REFERENCE DE-2026/43 (SSD-97973958)
Date 14 April 2026

WOLLONGONG COUNCIL SUBMISSION TO STATE SIGNIFICANT DEVELOPMENT APPLICATION

SSD reference:	SSD-97973958
Project title	Early Works for Shop Top Housing development
Stage	Exhibition following preparation of EIS -
Exhibition timeframe:	1 April to 14 April 2026
Location	Lot 7 DP 661845 Lot 6 DP 14480 Lot 1 DP 201949 Lot 2 DP 201949 357–359 Crown Street, 363 Crown Street, 2 & 4 Gladstone Avenue WOLLONGONG NSW 2500
Project specifics	Enlargement of basement excavation extent approved under DA-2023/156
Any existing approval	DA-2023/156

APPENDIX 1 – TREE LOCATION PLAN

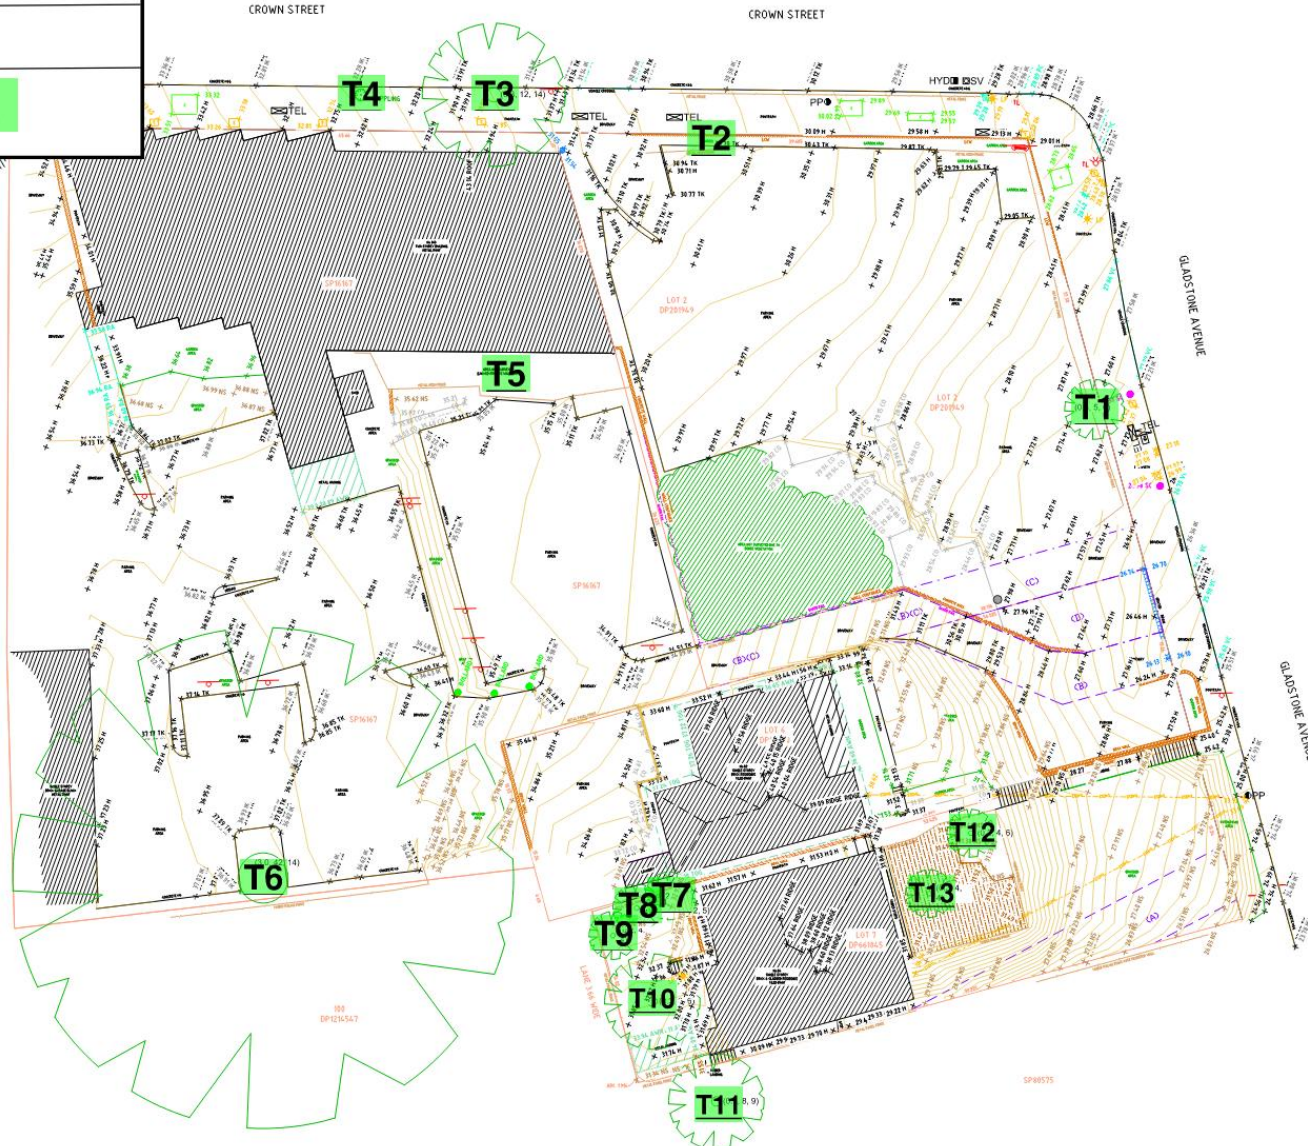
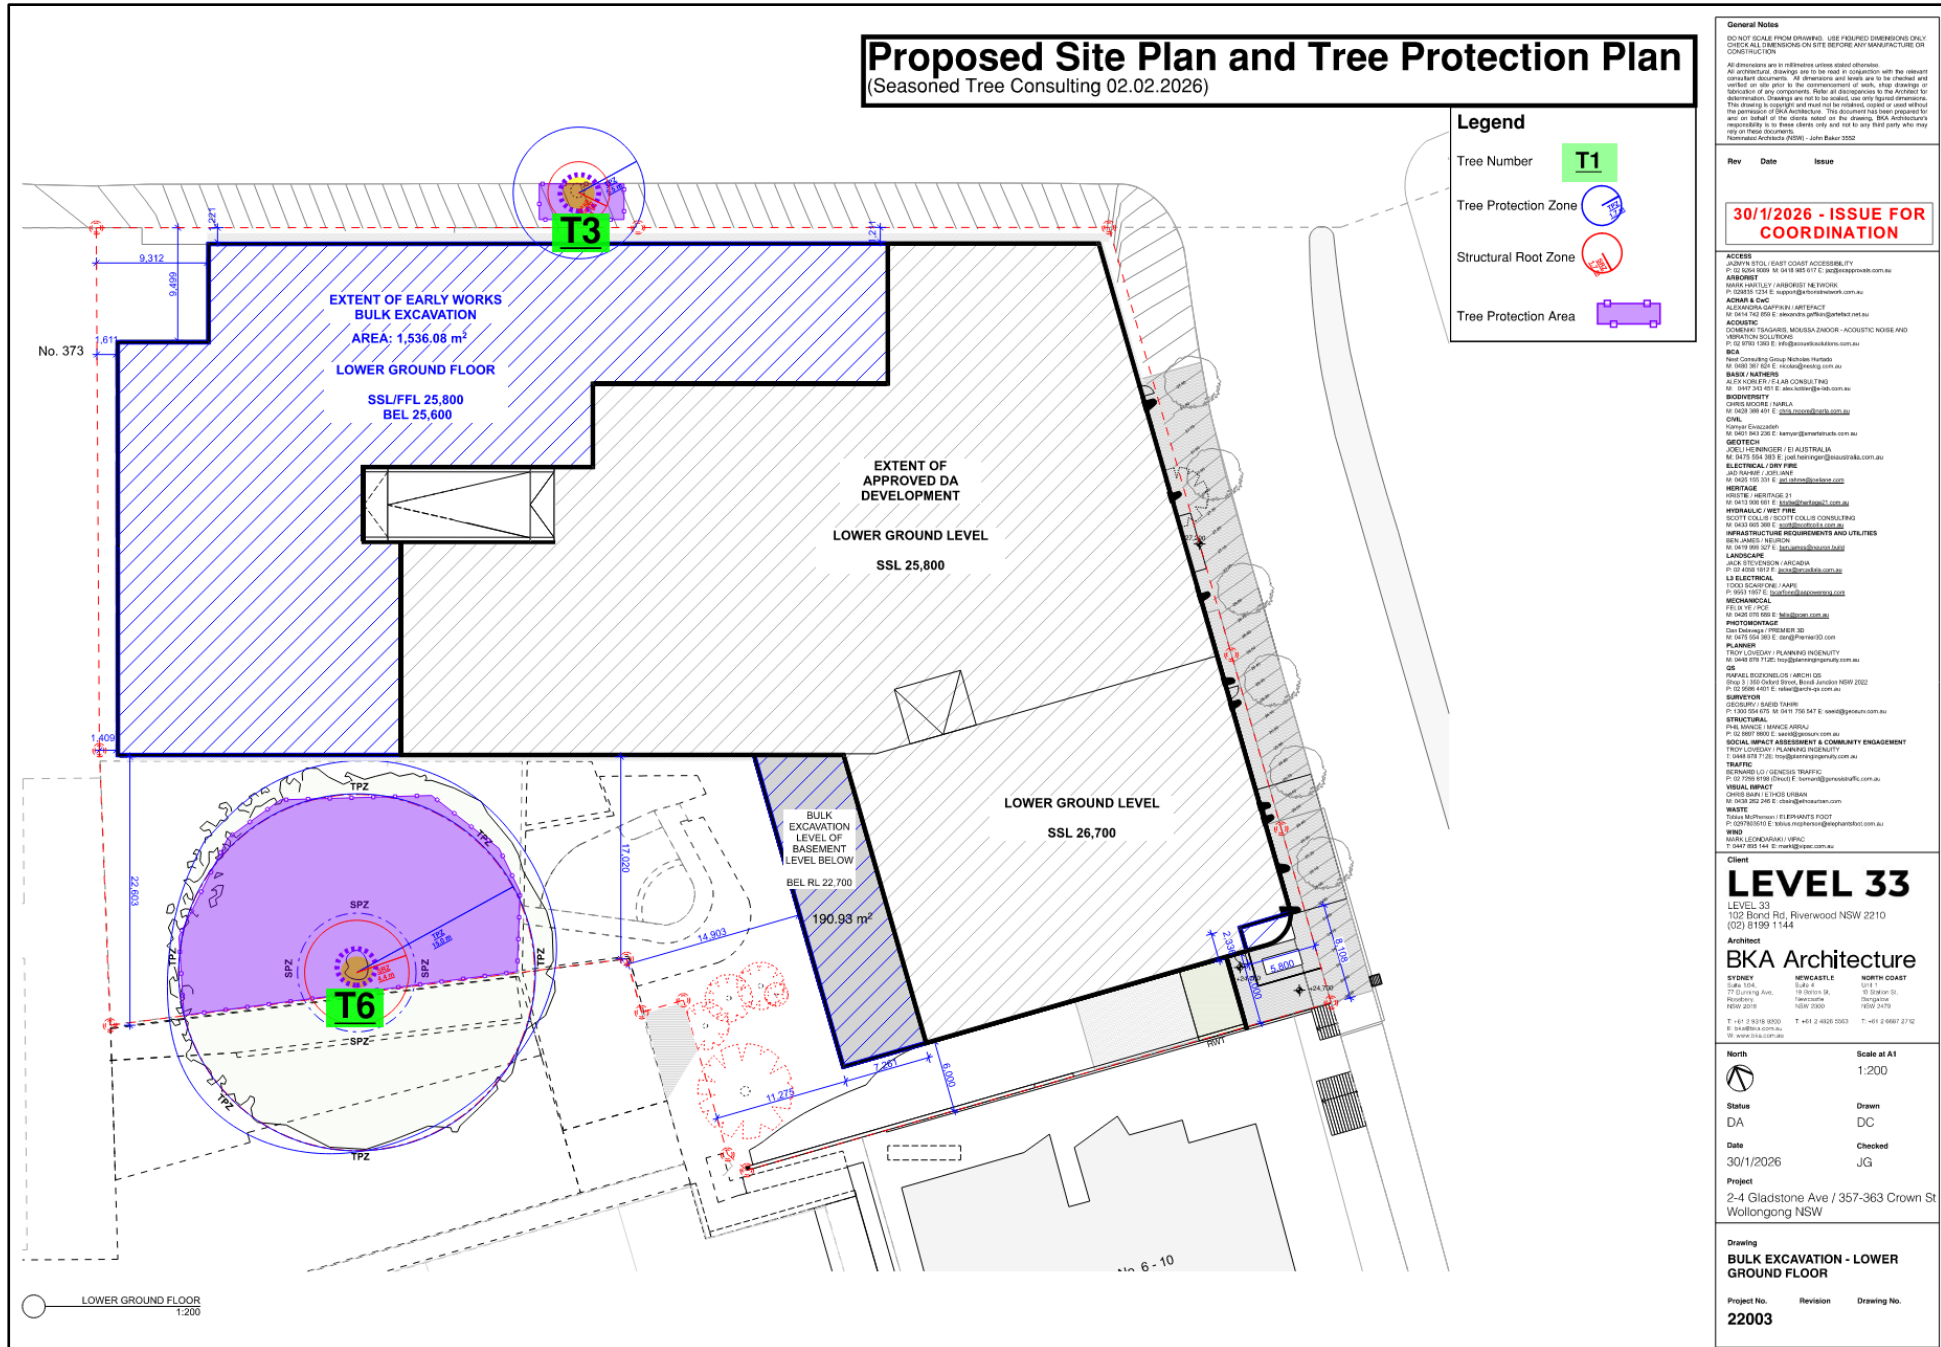
- The Arborist Report (Seasoned Tree Consulting dated 2 February 2026) does not discuss potential impacts to the heritage listed tree arising from the additional basement extent in terms of access to groundwater.
- Construction impacts: Council notes the updated Construction Noise and Vibration Management Plan (Acoustic Logic dated 11 February 2026) and Geotechnical Investigation (Foundation Earth Sciences 20 February 2026). Conditions of DA-2023/156 remain applicable – high strength material will be encountered that will require noise and vibration mitigation measures to be implemented.
